From: Judith Ward
Sent: 09 September 2019 11:04
To: Shona King
Subject: 19/01410/REM Bunkers Hill Shipton on Cherwell

Judith Ward
Landscape Planning Officer
Cherwell District & South Northants Councils

**Project No**  
 PLANTING PLAN (SHEET 1)

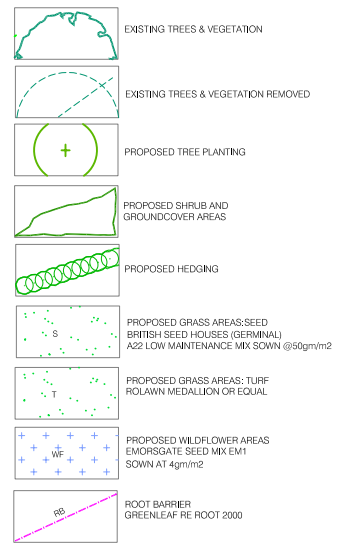
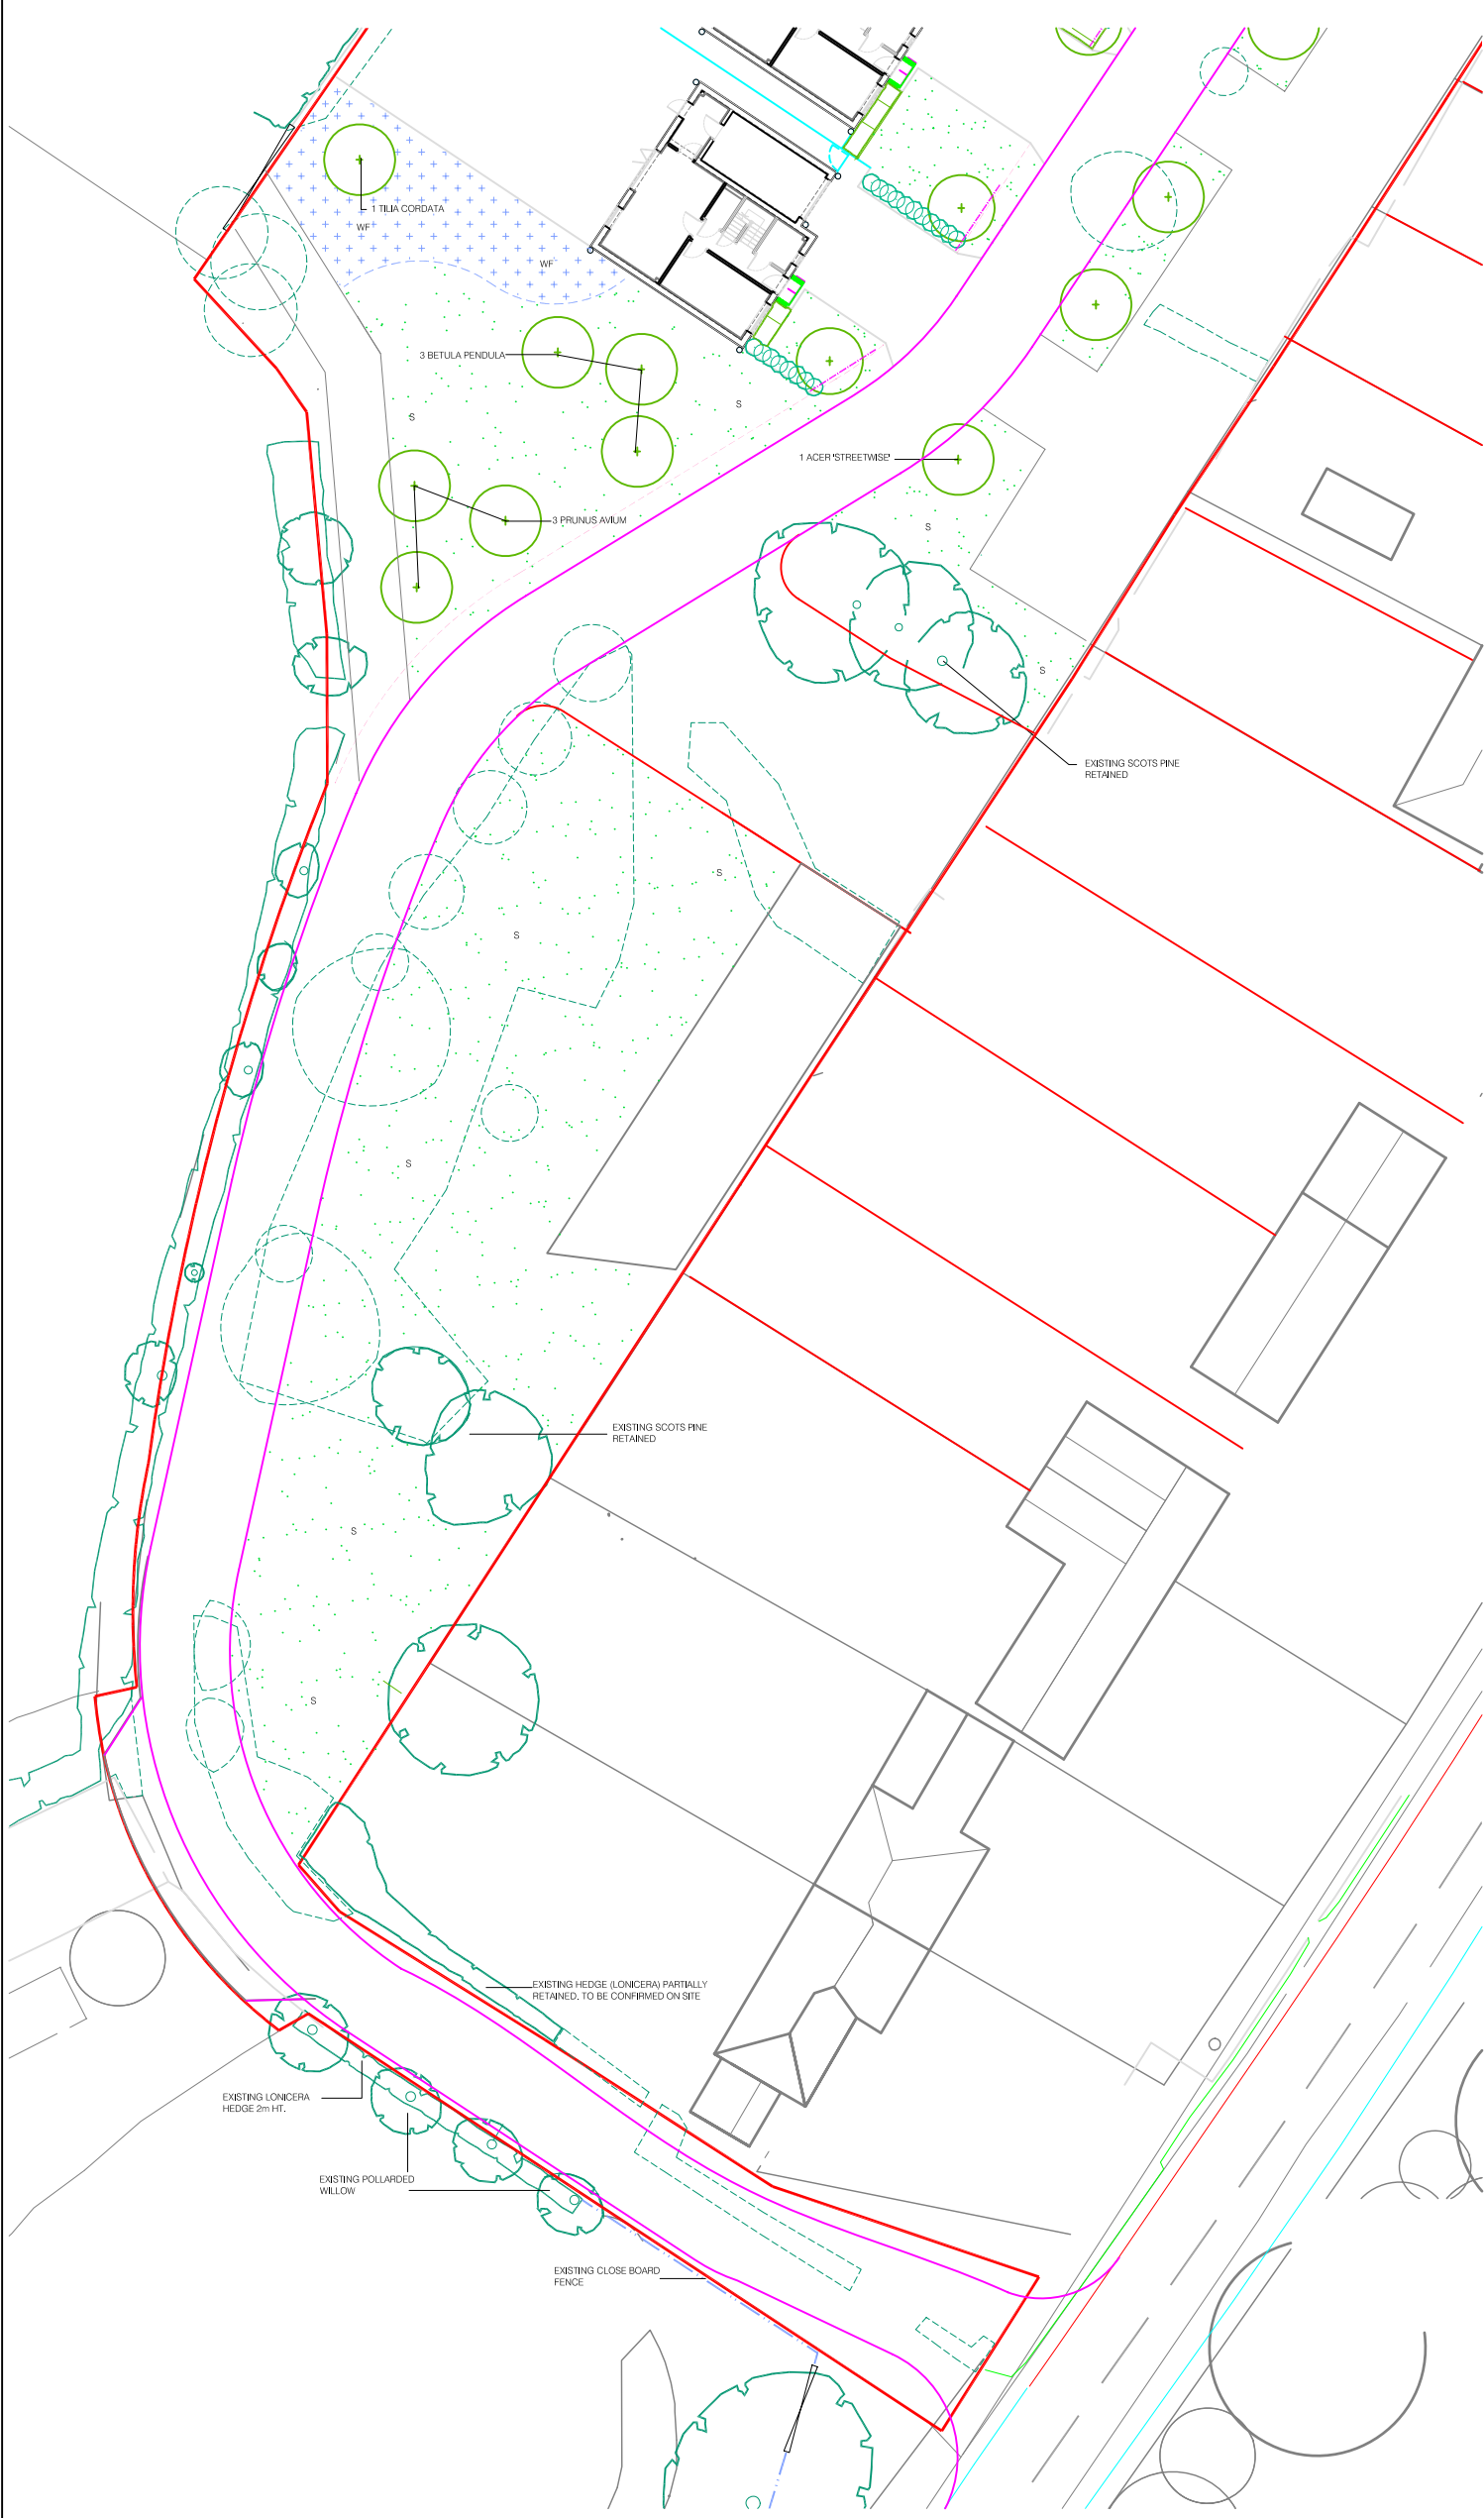
The provision of the unequipped LAP is appropriate as we can't request an equipped LAP due to our SPD requirements. They need to put a 1.0m high bow top metal fence around it. Gates should open outwards and there must be no dog signs set into the ground at the entrance. There should be some planting for texture, colour and scent. The bin should be located further away from the seat which should have arms and a back.

I have some concerns regarding comments made by a resident of Bunkers Hill that the developer is showing mitigation planting on land that they do not own. Please seek clarification from the developer that they own all the land that they are showing planting on. They cannot include land that they may have a right of way over but do not own outright. They should not be removing vegetation from land they do not own without permission. There does need to be mitigation planting but it must be on developer owned land.
